# ENG-SF21012-R2-CD-redlines.pdf Markup Summary

**Subject:** Engineer  
**Page Index:** 23  
**Date:** 5/14/2021 5:10:19 PM  
**Author:** CFurchak  
**Color:** ■  
**Layer:**  
**Space:**  
**Page Label:** [23] C3.22 POND DETAILS

OUTLET STRUCTURE PROFILE N.T.S.

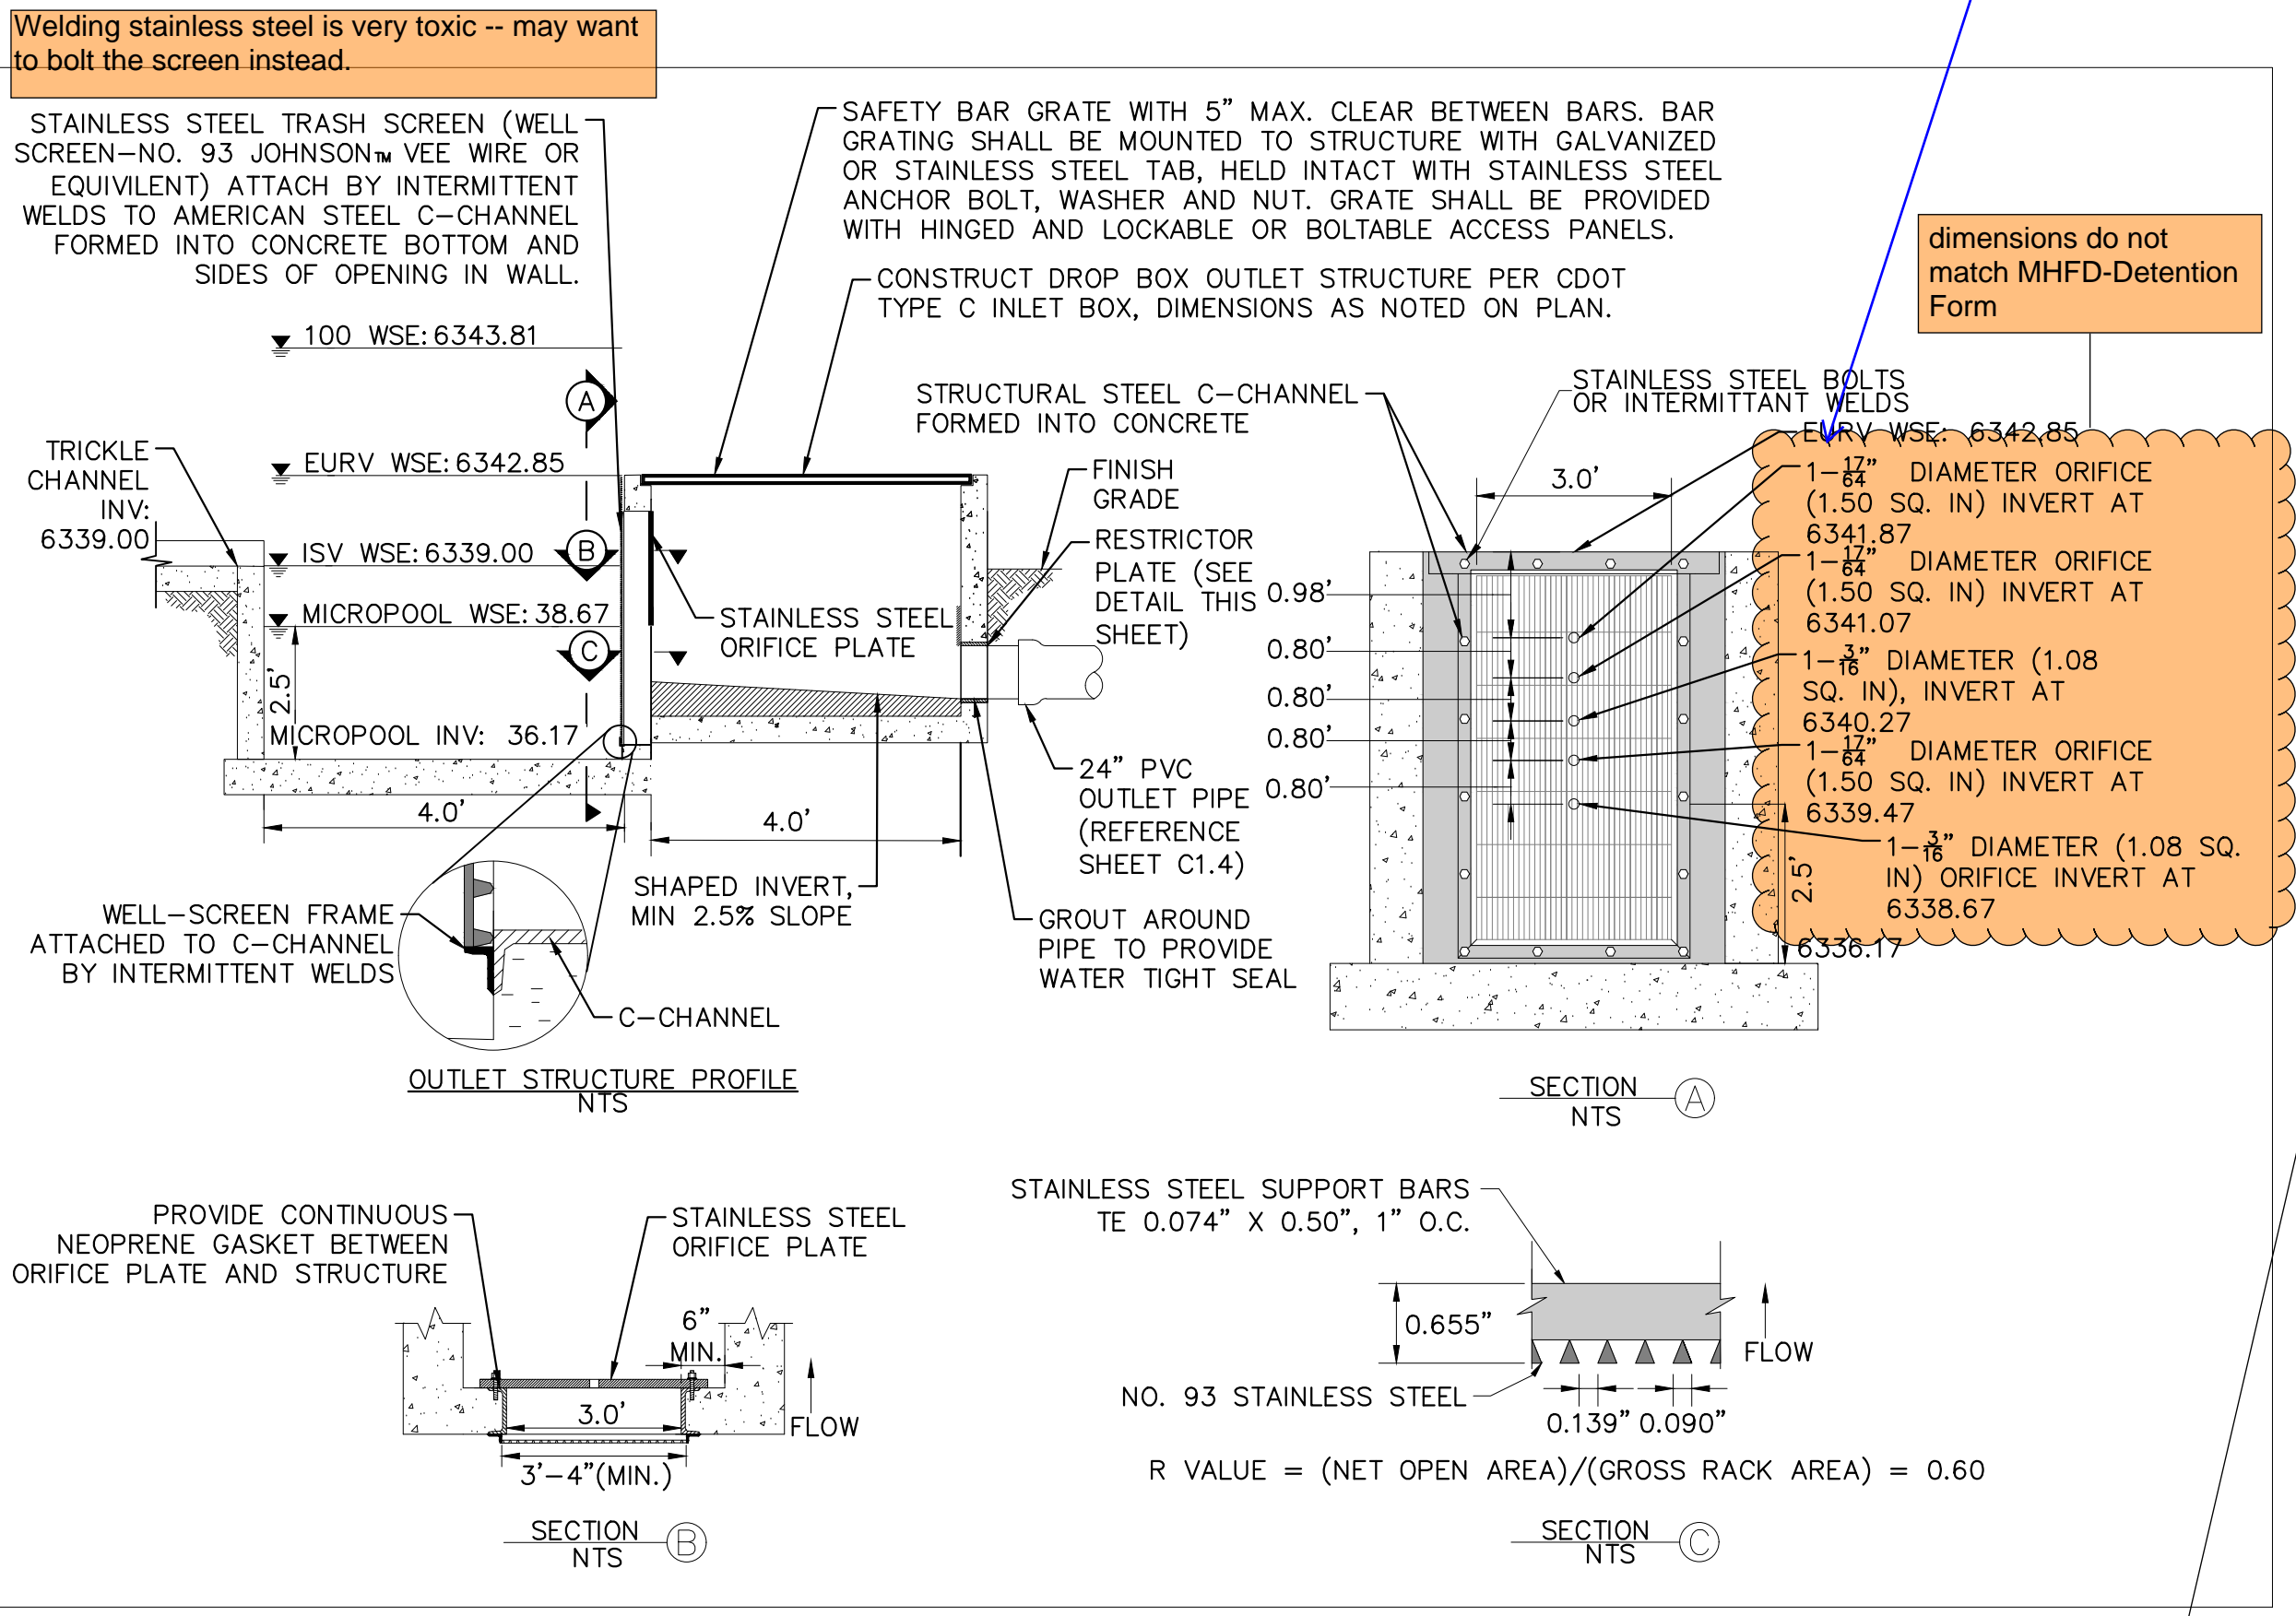
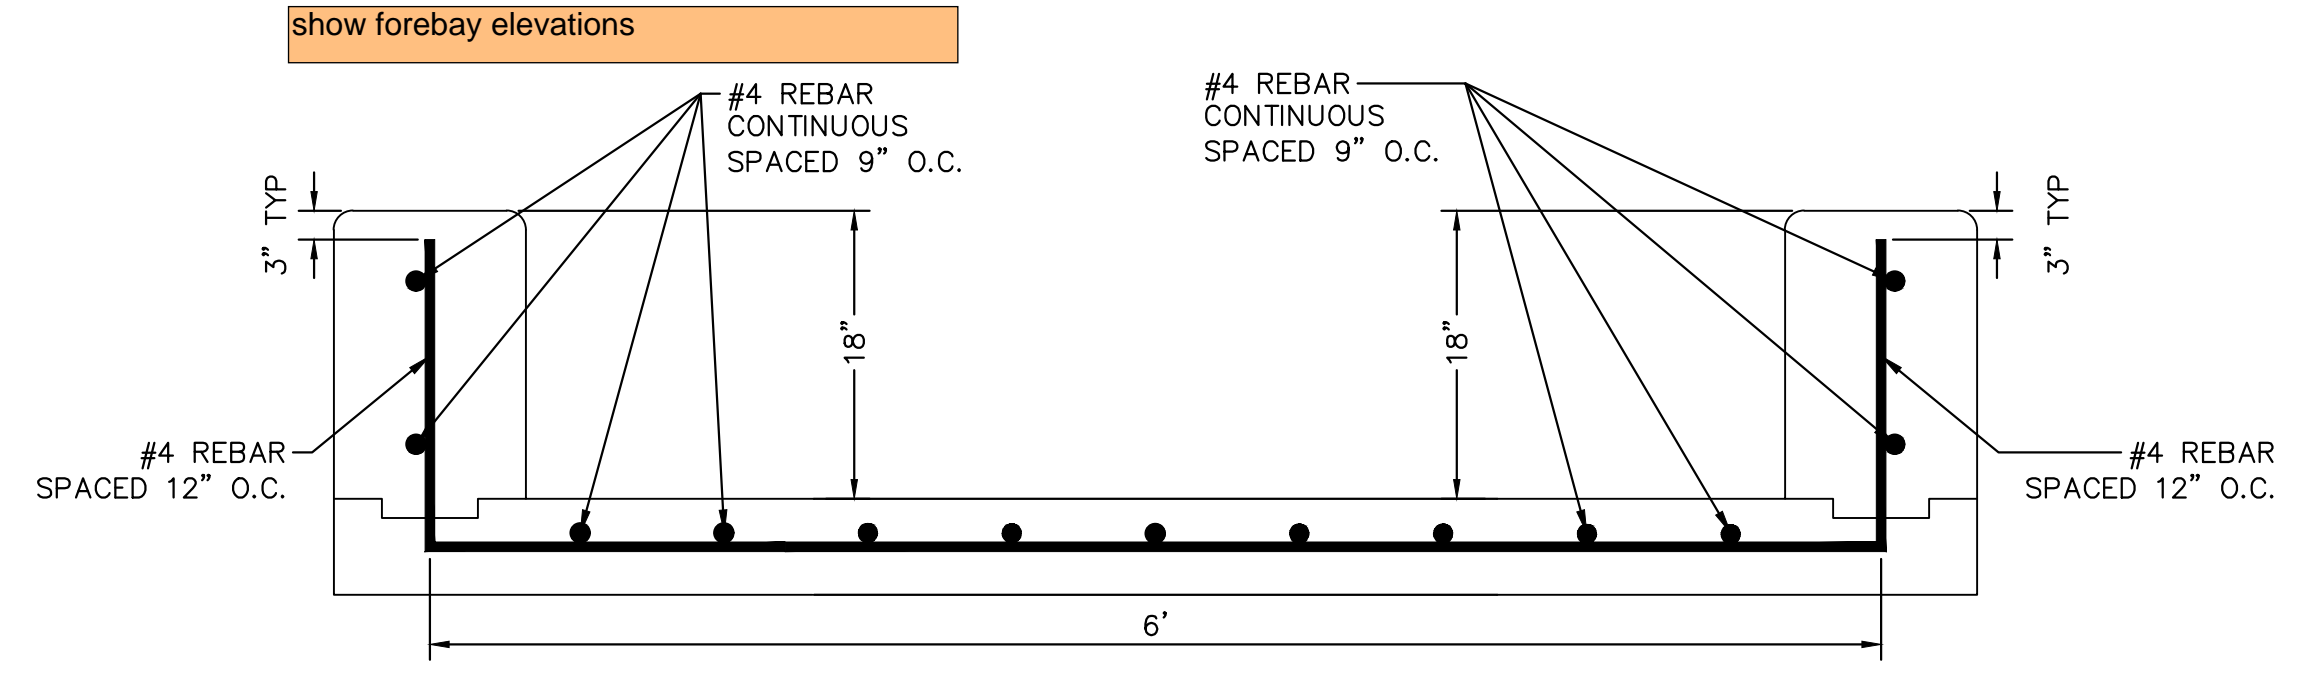
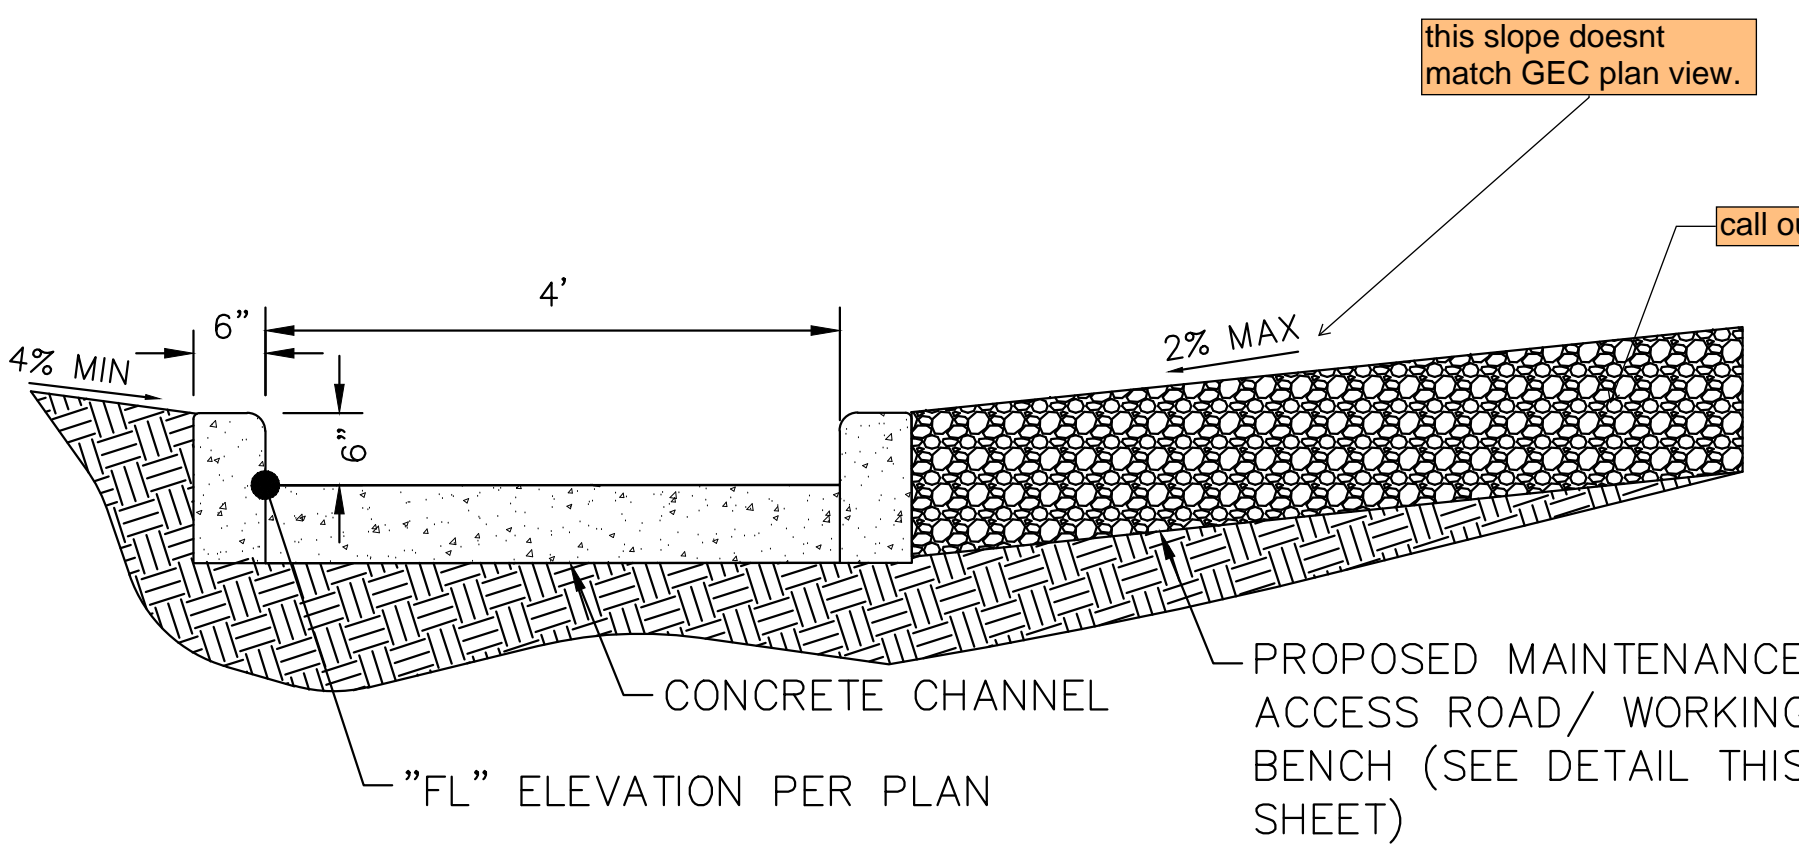
elevations are 100' off from plan view

PROPOSED 70'-WIDE  
EMERGENCY SPILLWAY  
Clearly define location/  
width of spillway and  
elevations

clearly define location/ width of spillway and  
elevations

Verify design details based on entire contributing area
